Isleham Parish Council 20030170
Comments on Further Information Received
Deadline10

Sunnica have stated in doc 8.112 *The Applicant's position on 'parcel by parcel' mitigation and residual effects REP8-026* ([EN010106-005400-8.112 The Applicant's position on 'parcel by parcel' mitigation and residual effects.pdf \(planninginspectorate.gov.uk\)](#) pg 6 that there is no access to the plane crash site.

Drawing Title  
**FIGURE 10-14C  
 LANDSCAPE MASTERPLAN  
 SUNNICA EAST SITE B**

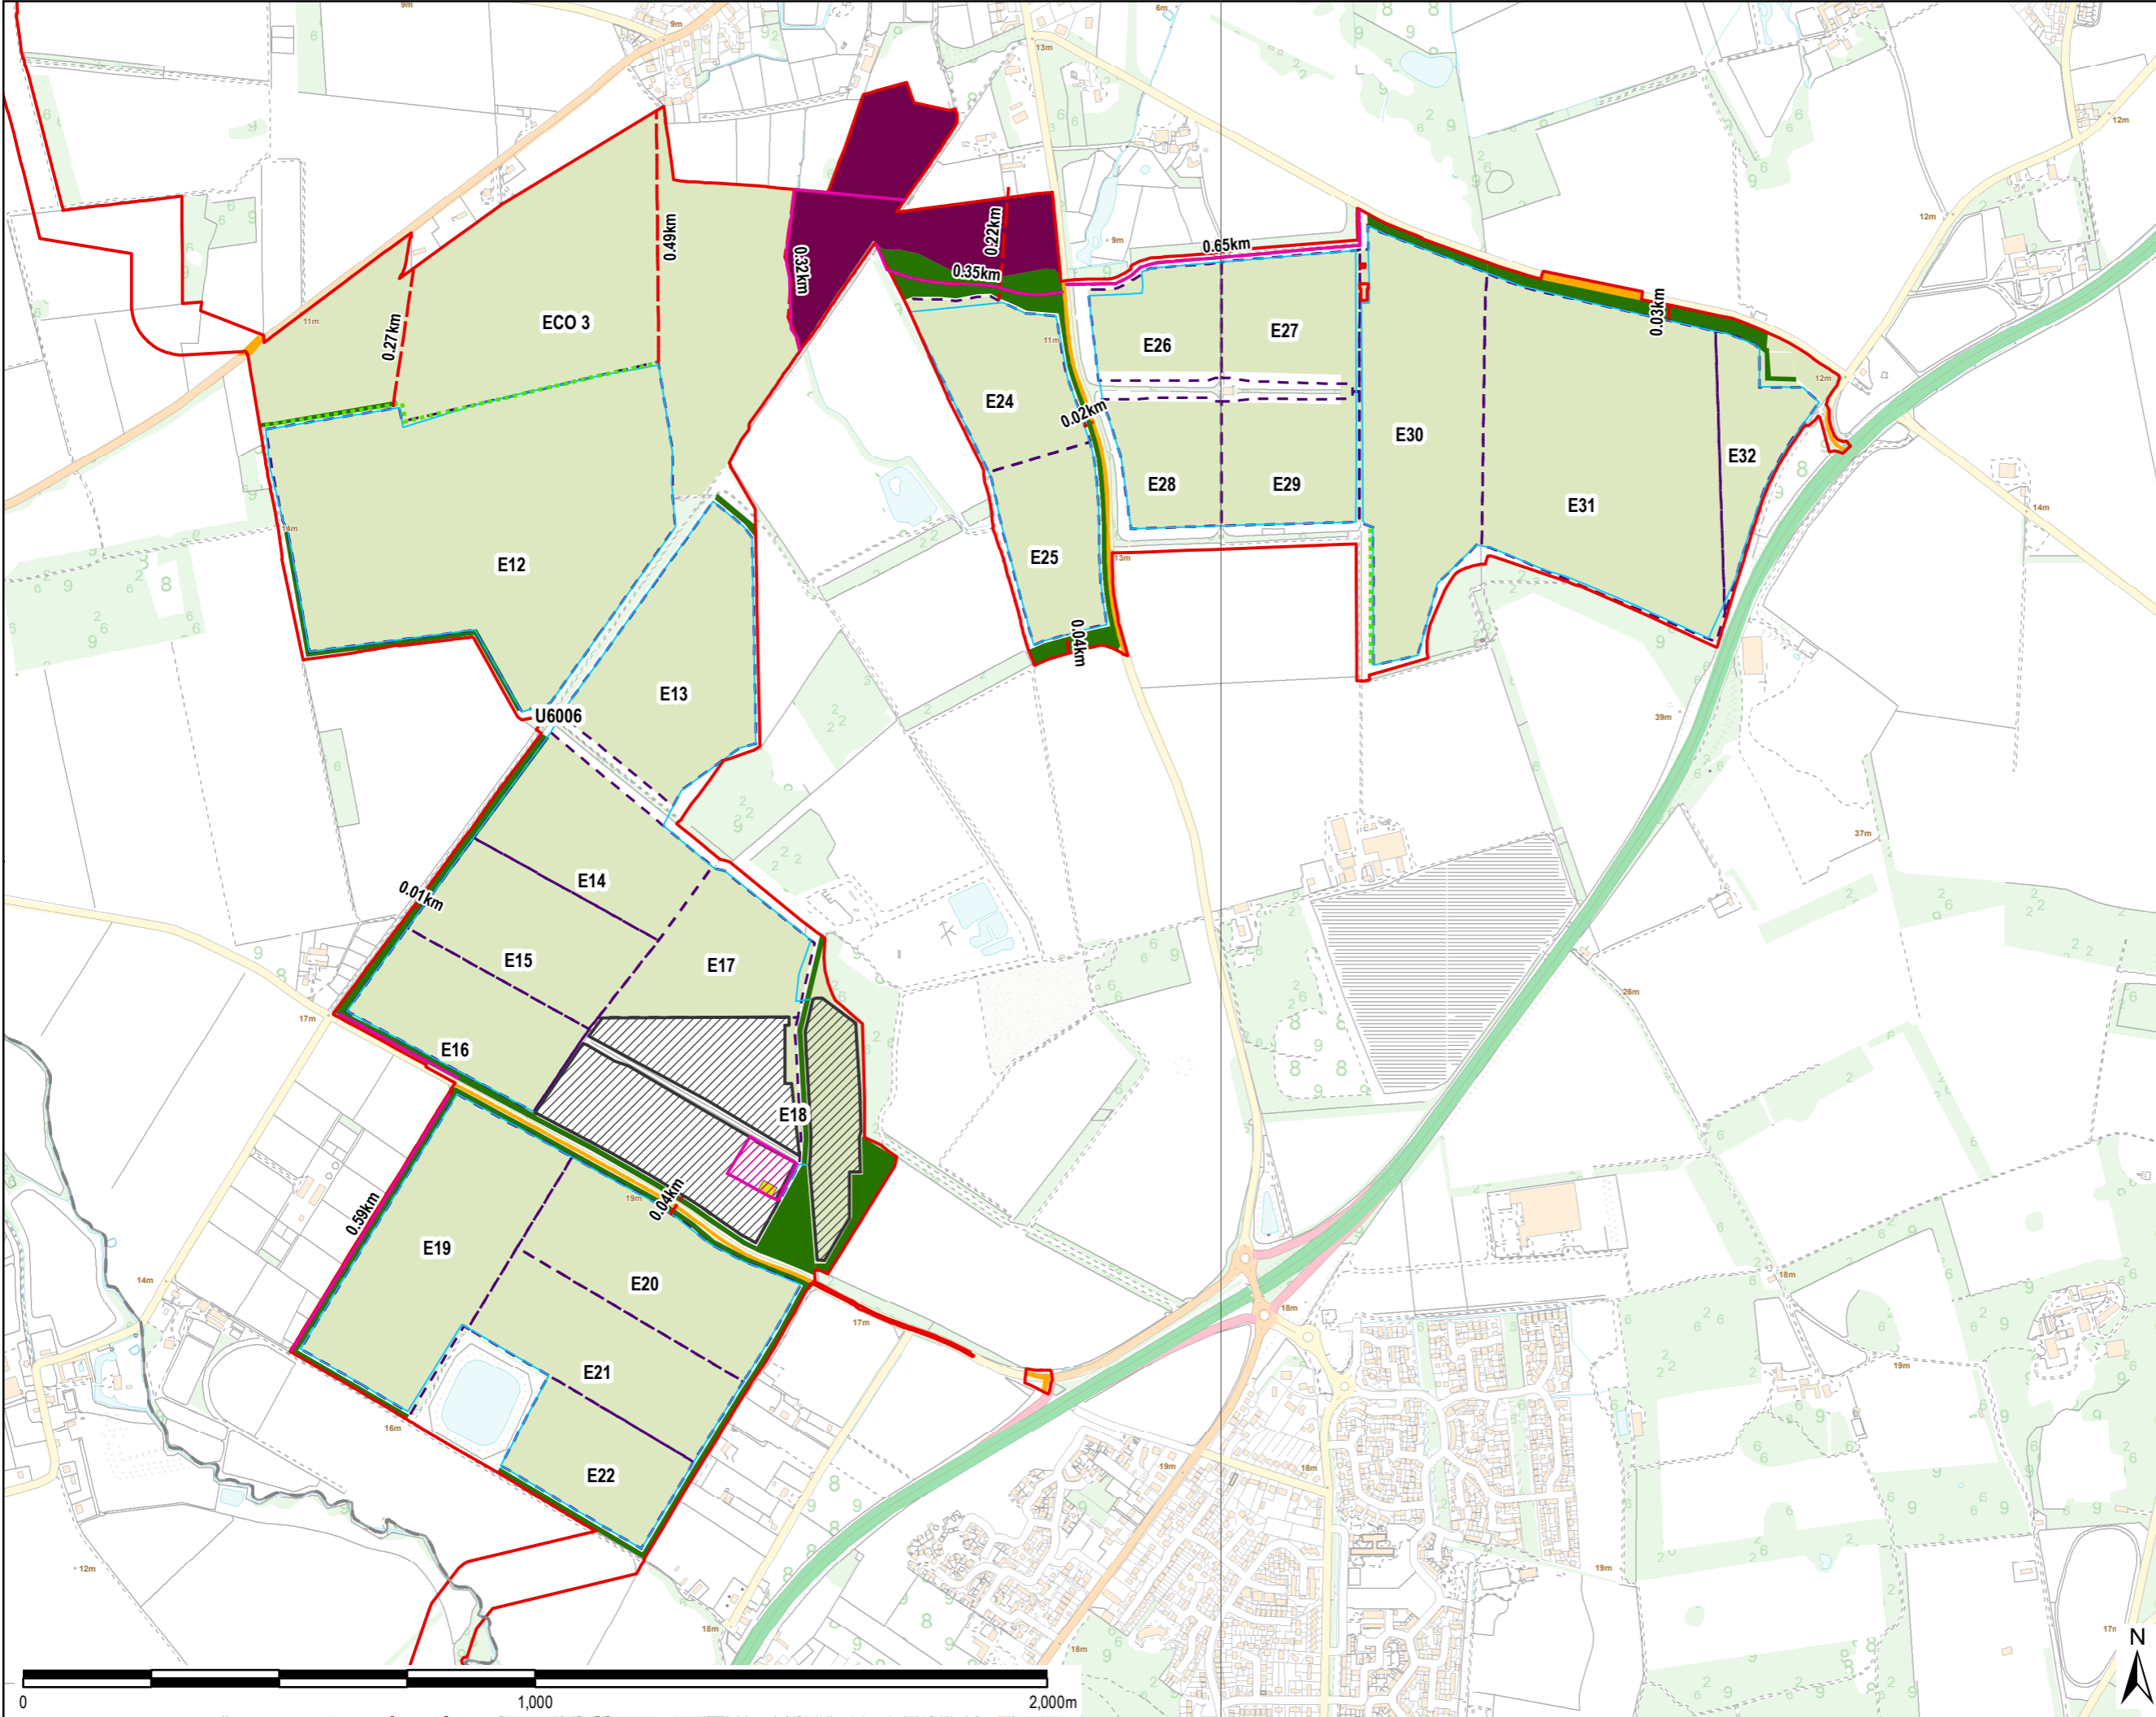
This is something that would change completely if development in parcel E05 were allowed, as both the mitigation planting and the panels and fencing themselves would block visual access to the crash site. This has been mentioned in previous submissions. The crash site is spread over a wide area of parcel E05, it is not simply the primary crater. It would also mean that physical access to the area would be lost for over 40 years.
